Our Ref: EP/147/19/NMA

**Section 96A of the Town & Country Planning Act 1990 (as amended)
Town and Country Planning (Development Management Procedure) (England) Order 2015 (as amended) - Article 10**

Non-material amendment following the grant of reference EP/56/19/HH to provide 2000 x 400mm lounge window frame to the western elevation
12 Willowhayne Avenue East Preston BN16 1PC

sheet 1 b of 4

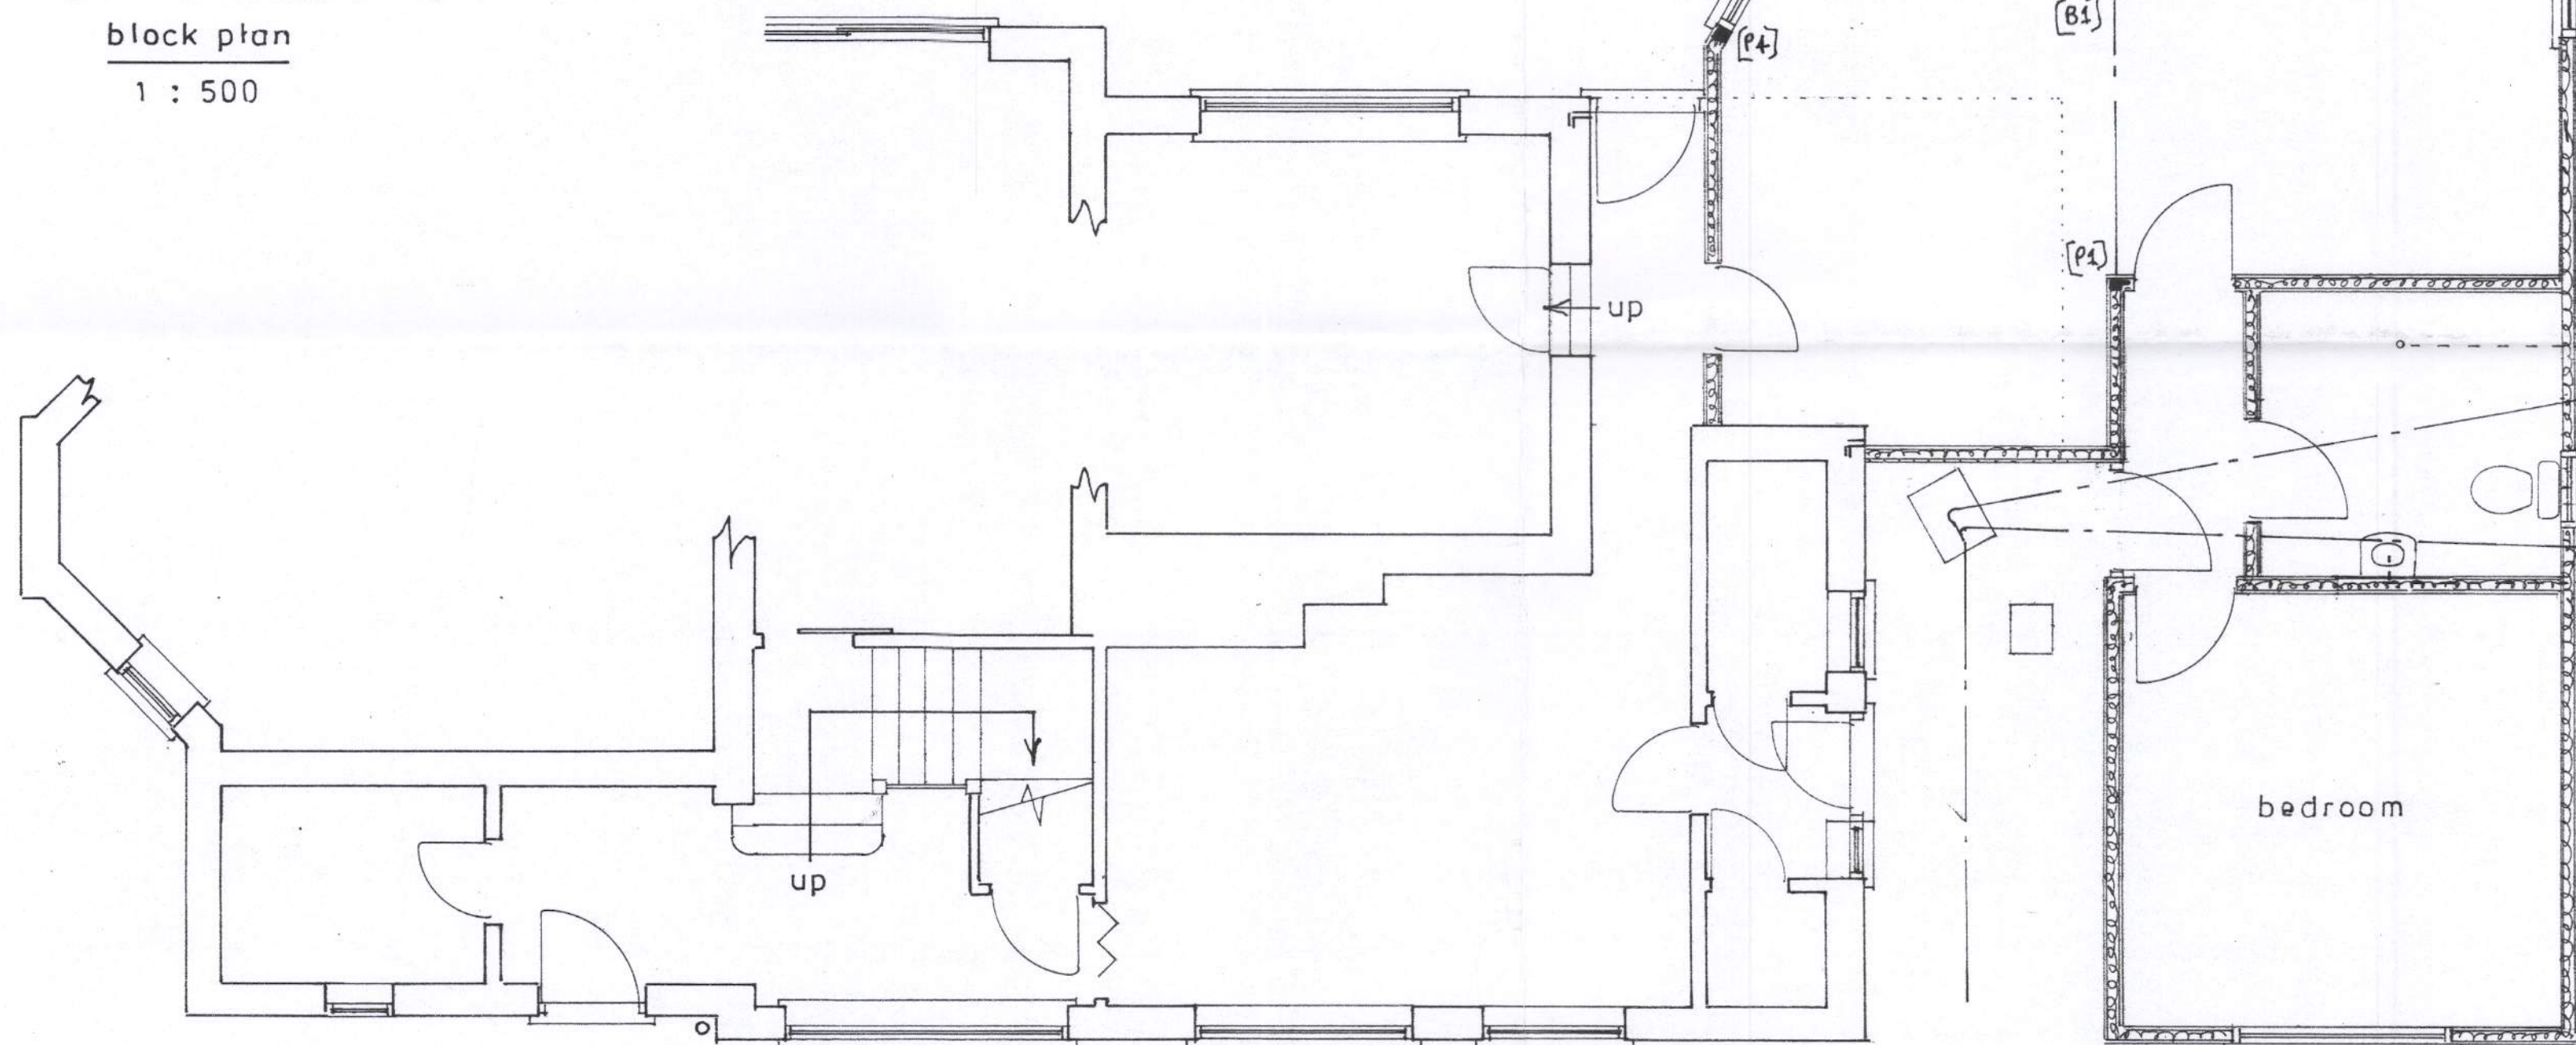
I refer to your recent application for a Non Material Minor Amendment. I note that you seek to insert a window into the Western elevation of the lounge.

Please note that plans 'Proposed Single Storey and 1st Floor Extensions - Block Plan & Proposed Ground Floor Plan - 1 of 4' and 'Proposed Single Storey and 1st Floor Extensions - Proposed Elevations & Roof Plans - 3 of 4' are replaced by 'Proposed Single Storey and 1st Floor Extensions - Block Plan & Proposed Ground Floor Plan - 1b of 4' and 'Proposed Single Storey and 1st Floor Extensions - Proposed Elevations & Roof Plans - 3a of 4'.
